11 May 2021

Your Ref: SSD-6966-MOD-1

Advice on Response to Submissions – Barangaroo Building R5 Mod 1 Design Amendments – SSD-6966-MOD-1

- MODIFICATION:
1. UPDATED LEVEL'S FFL
 2. REMOVED EXTERNAL SHADING DEVICES
 3. UPDATED PODIUM FACADE
 4. UPDATED AWNING DETAILS
 5. ADDED AWNING
 6. SHOWN INDICATIVE RETAIL DOOR LOCATION
 7. UPDATED BALCONIES TO FULL HEIGHT GLAZING FACADES

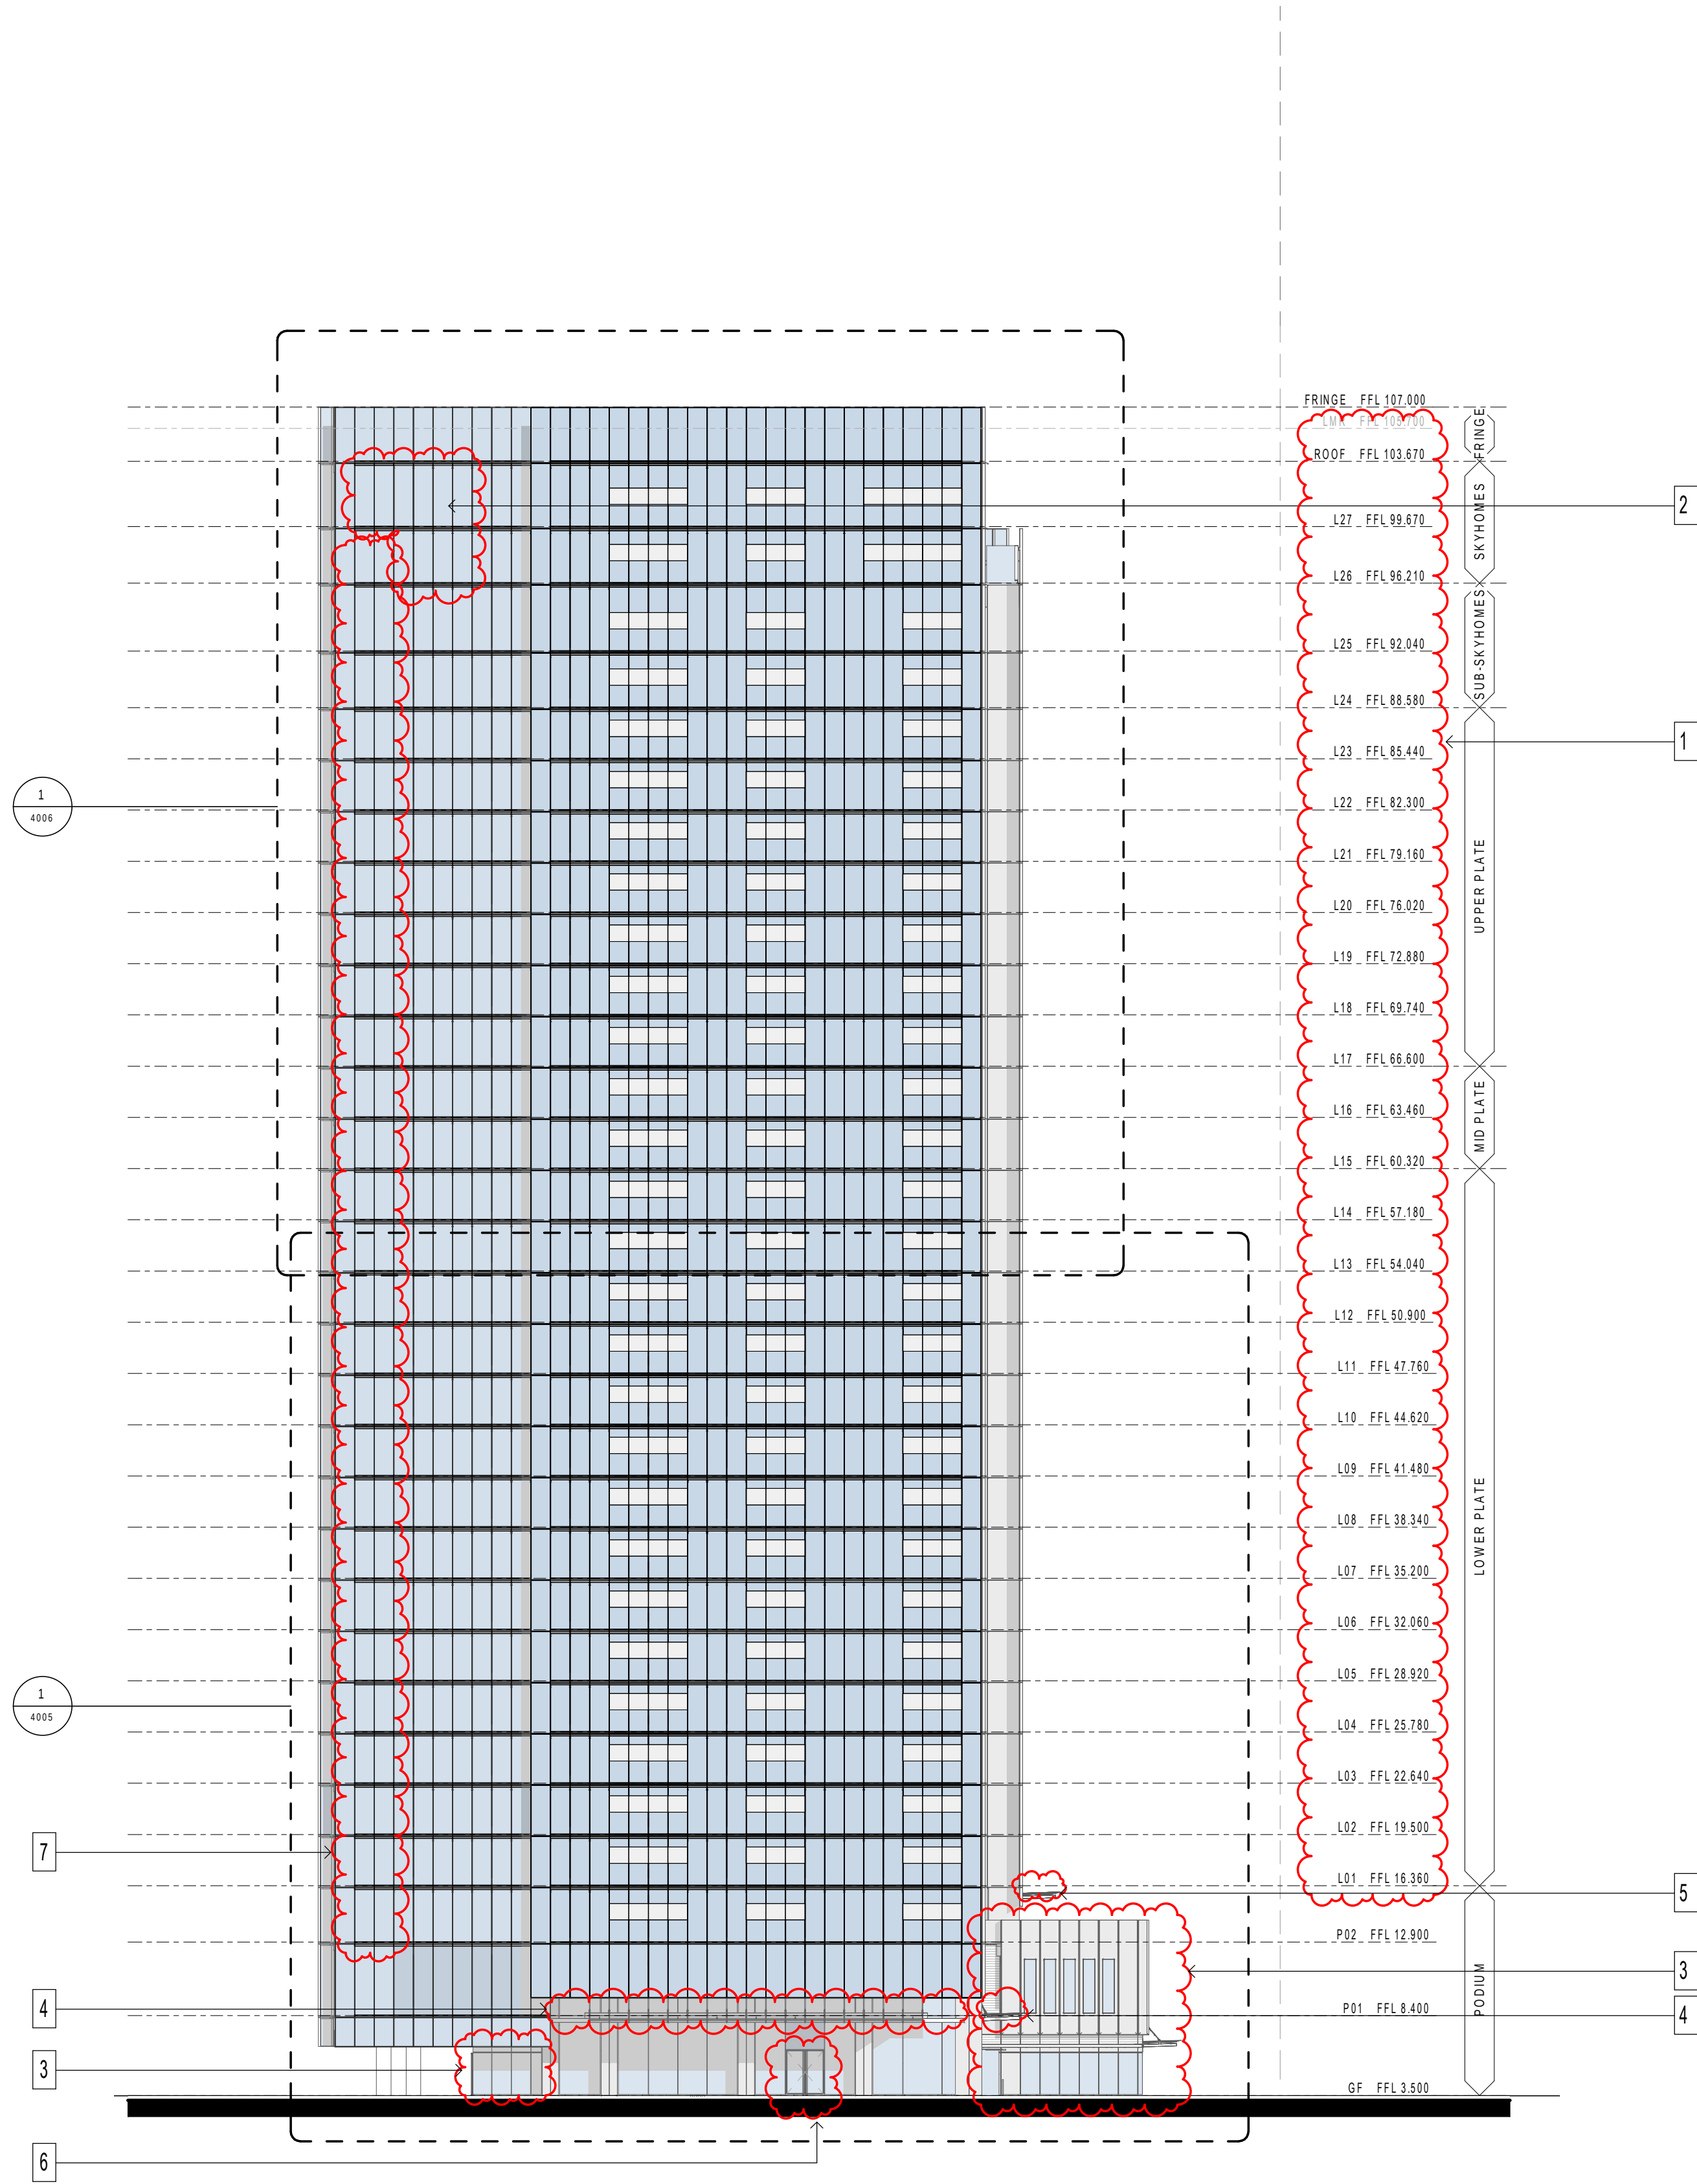
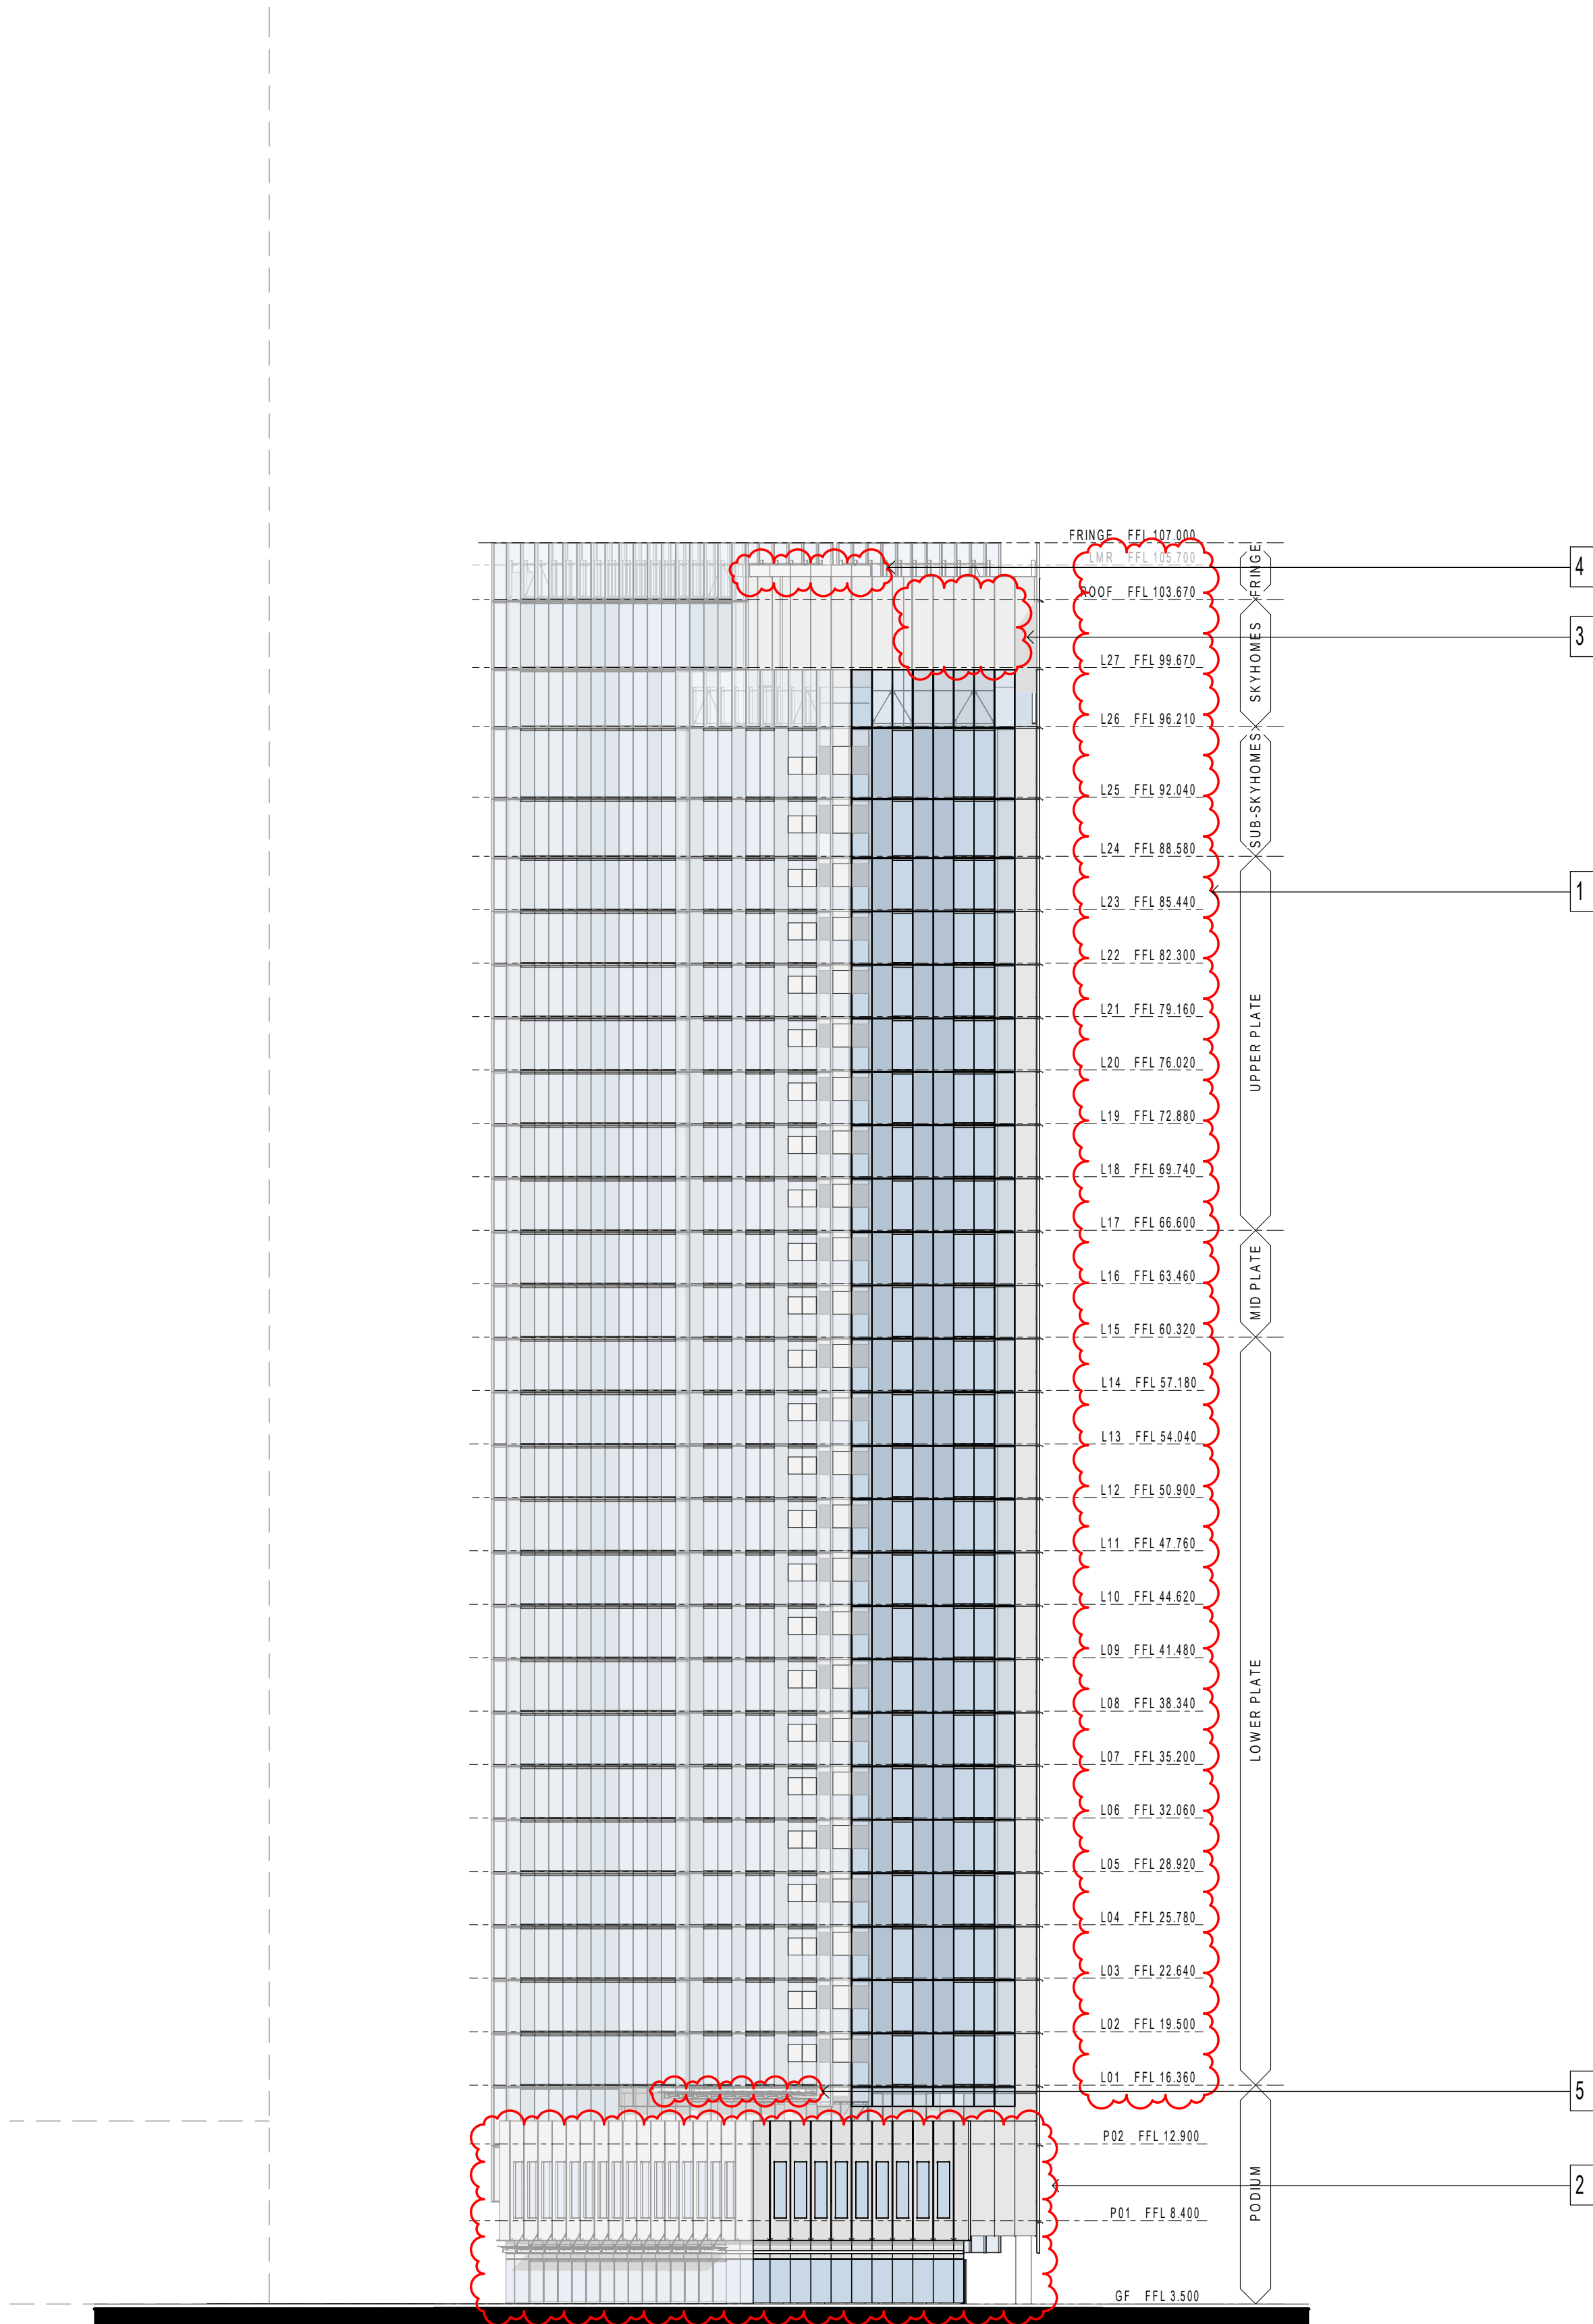
Noted as item 7 on the submitted elevations, it is not clear if the intention for full height glazed facades are for wintergardens or an enclosed balcony (a room) as the elevation appear to show full height glazing.

Section 4.2.3.13 of the Sydney Development Control Plan 2012 notes that wind-affected balconies require at least 25% of the external face of the balcony to be permanently open however, it is not clear if this amended scheme achieves this. Detailed section drawings are recommended to be submitted to clarify the amount of enclosure to the balcony and how the habitable rooms behind the enclosed balcony can maintain adequate access to natural ventilation.
